SSD-82160220 Mixed Use Development 184 Fifth Ave Austral

I refer to the Department's email of 14 July 2026 regarding the Environmental Impact Statement (EIS) for State Significant Development SSD-82160220 Mixed Use Development 184 Fifth Ave Austral for 'Construction of Mixed-Use Development comprising 2 buildings with 445 dwellings, a centre based childcare facility, gym, retail floor space and basement parking. Public domain works along Scalabrini Creek' at 184 - 186 Fifth Avenue, Austral (Lot 99 DP 1284142) in the Liverpool City Council local government area (LGA). Submissions need to be made to the Department by 11 August 2026.

Please refer to the attached copy of Endeavour Energy's submission made to the Department on 9 April 2025 regarding the request for Secretary's Environmental Assessment Requirements (SEARs) for SSD-82160220 Mixed Use Development 184 Fifth Ave Austral. The conditions and advice provided therein essentially remain applicable.

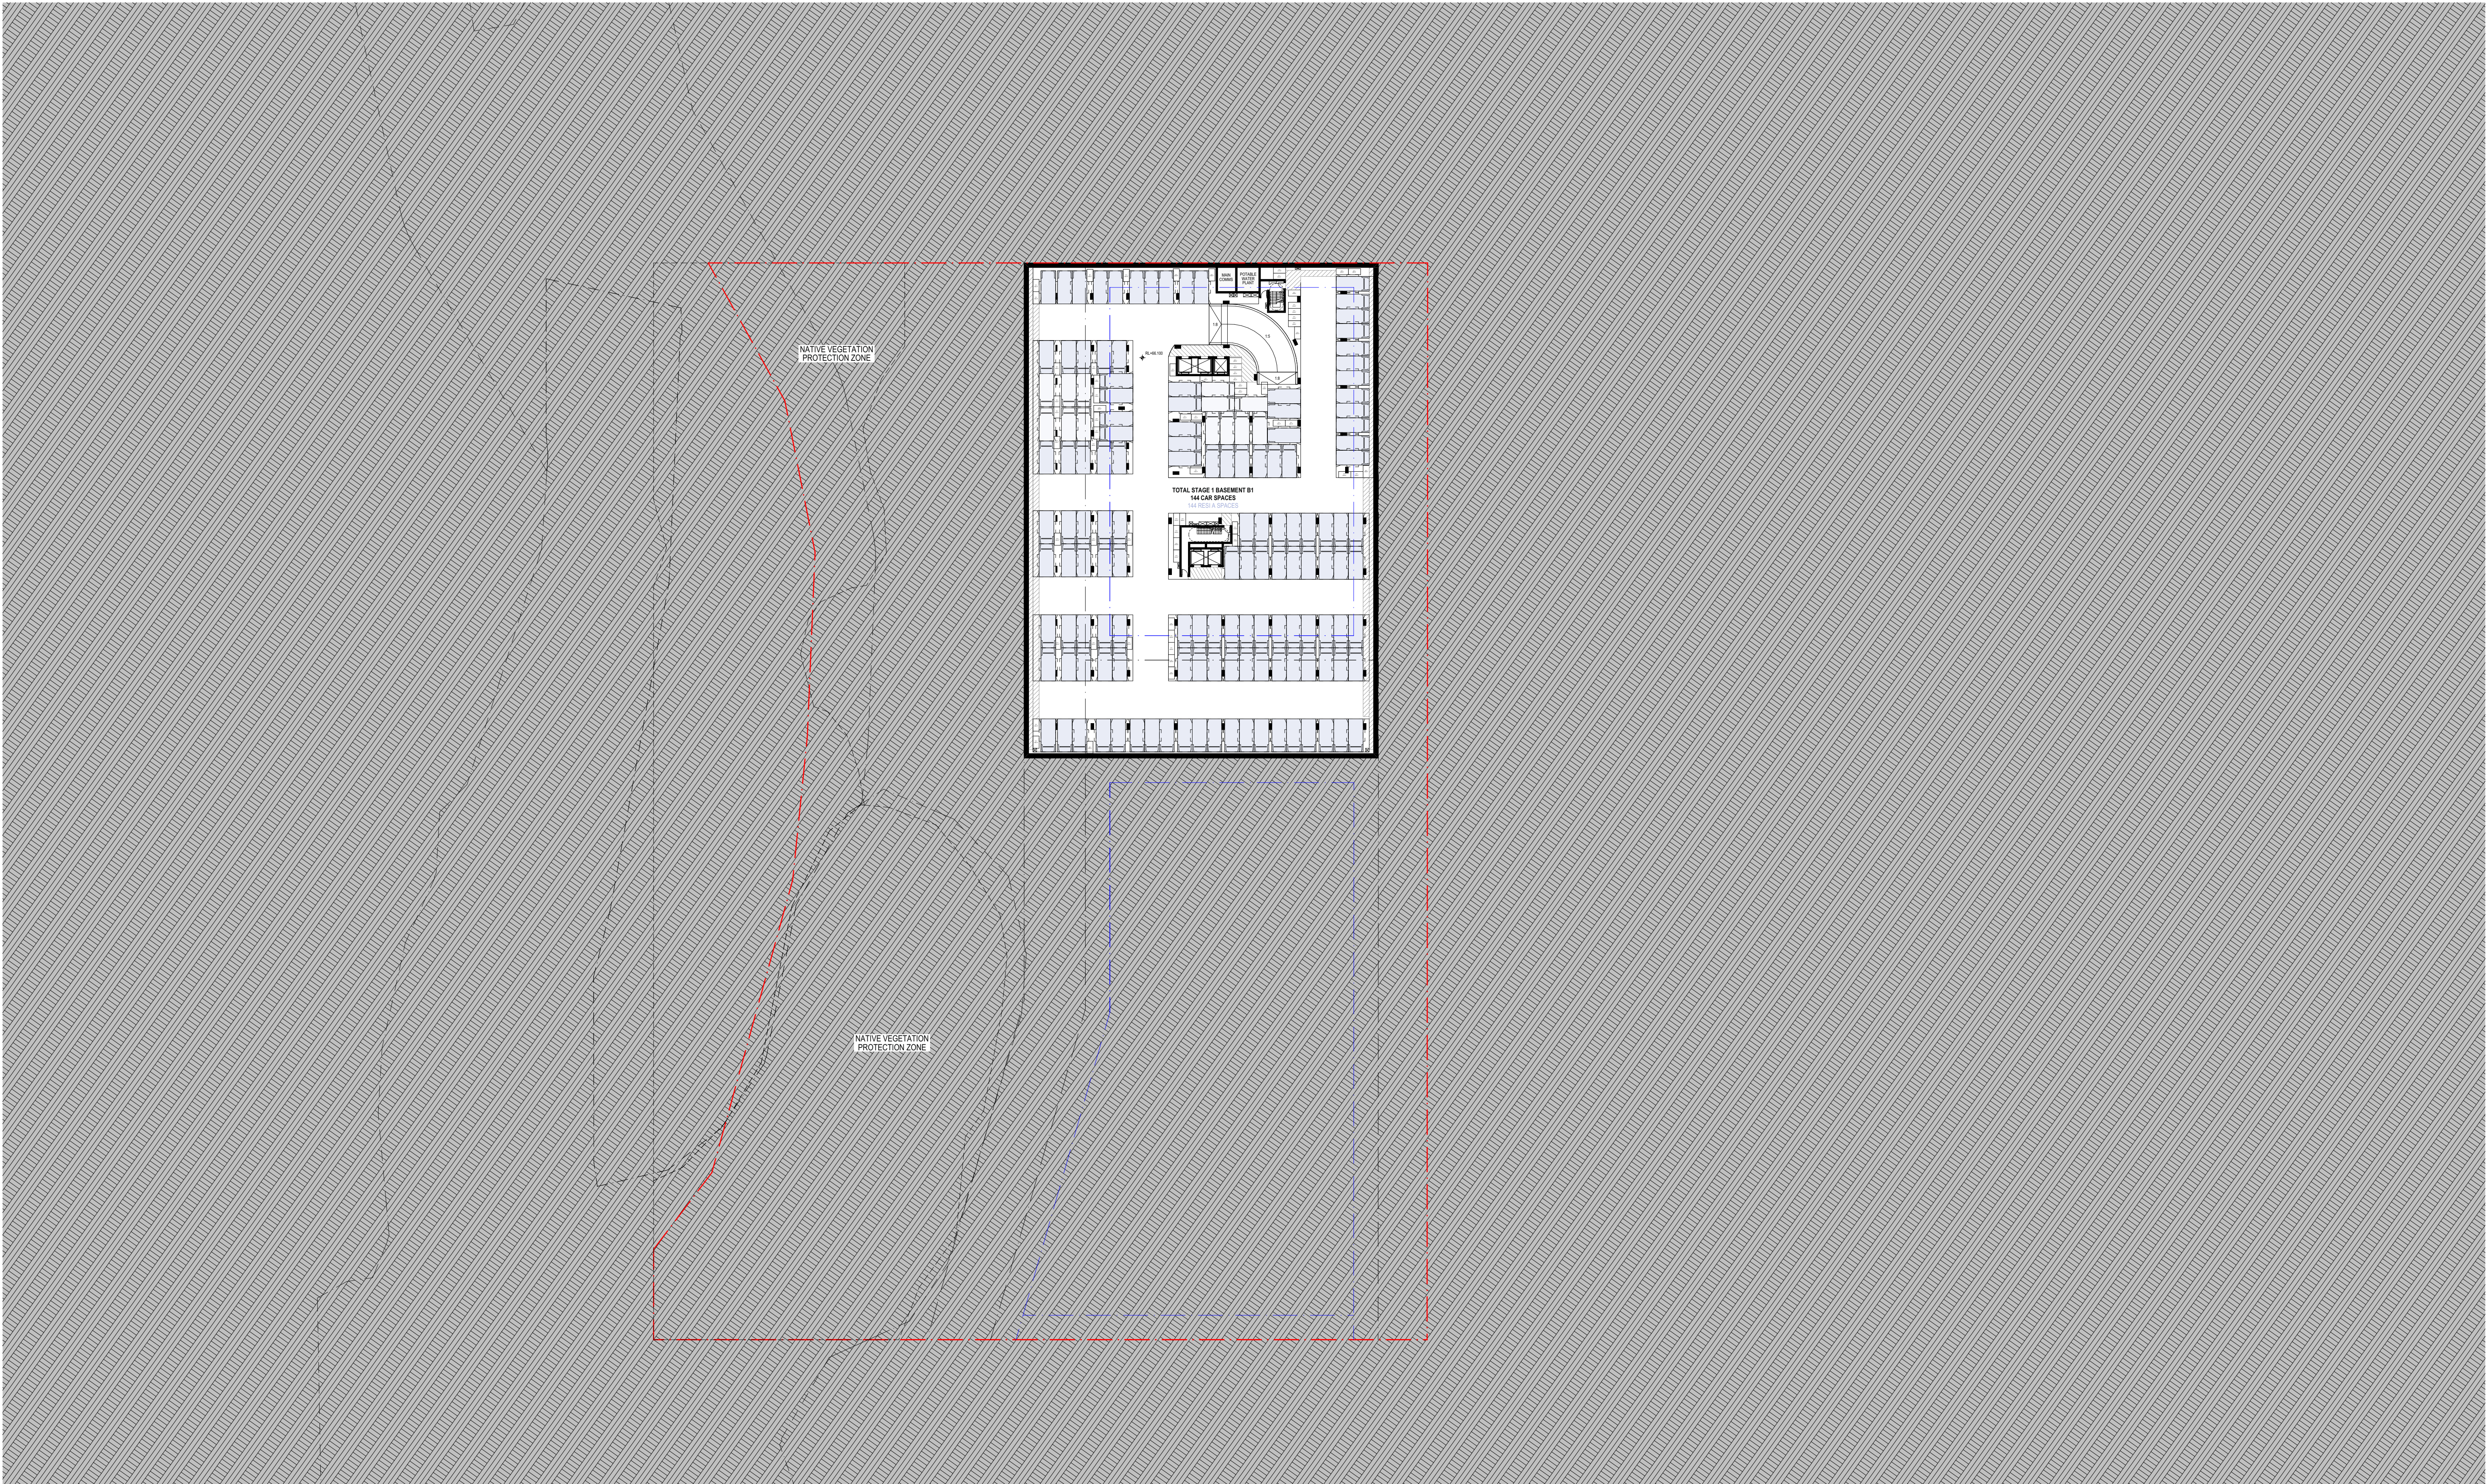
The below copy of the General Floor Plan - Ground 00 shows the provision of two 'Sub' locations. Any required padmount substation/s will need to be located within the property (in a suitable and accessible location) and be protected (including any associated cabling not located within a public road / reserve) with an appropriate form of property tenure as detailed in the attached copy of Endeavour Energy's 'Land Interest Guidelines for Network Connection'.

Generally it is the Level 3 Accredited Service Provider's (ASP) responsibility (engaged by the developer) to make sure substation location and design complies with Endeavour Energy's standards the suitability of access, safety clearances, fire ratings, flooding etc. If the substation does not comply with Endeavour Energy's standards, the applicant must request a dispensation.

Regarding the child care centre, whilst there may be no restrictions in legislation that stop sensitive uses such as schools, pre-schools, day / child care centres being placed next to electricity infrastructure, prudent avoidance measures should however be implemented.

As a guide, with the observance of the separation distances identified in Endeavour Energy's Mains Design Instruction MDI 0044 'Easements and Property Tenure Rights', Table 1 'Minimum easement widths', electric and magnetic fields (EMF) should not exceed the recommended magnetic field public exposure limits.

Nonetheless the applicant may wish to commission an independent review to provide an overall assessment and the consideration and adoption of prudent avoidance principles.
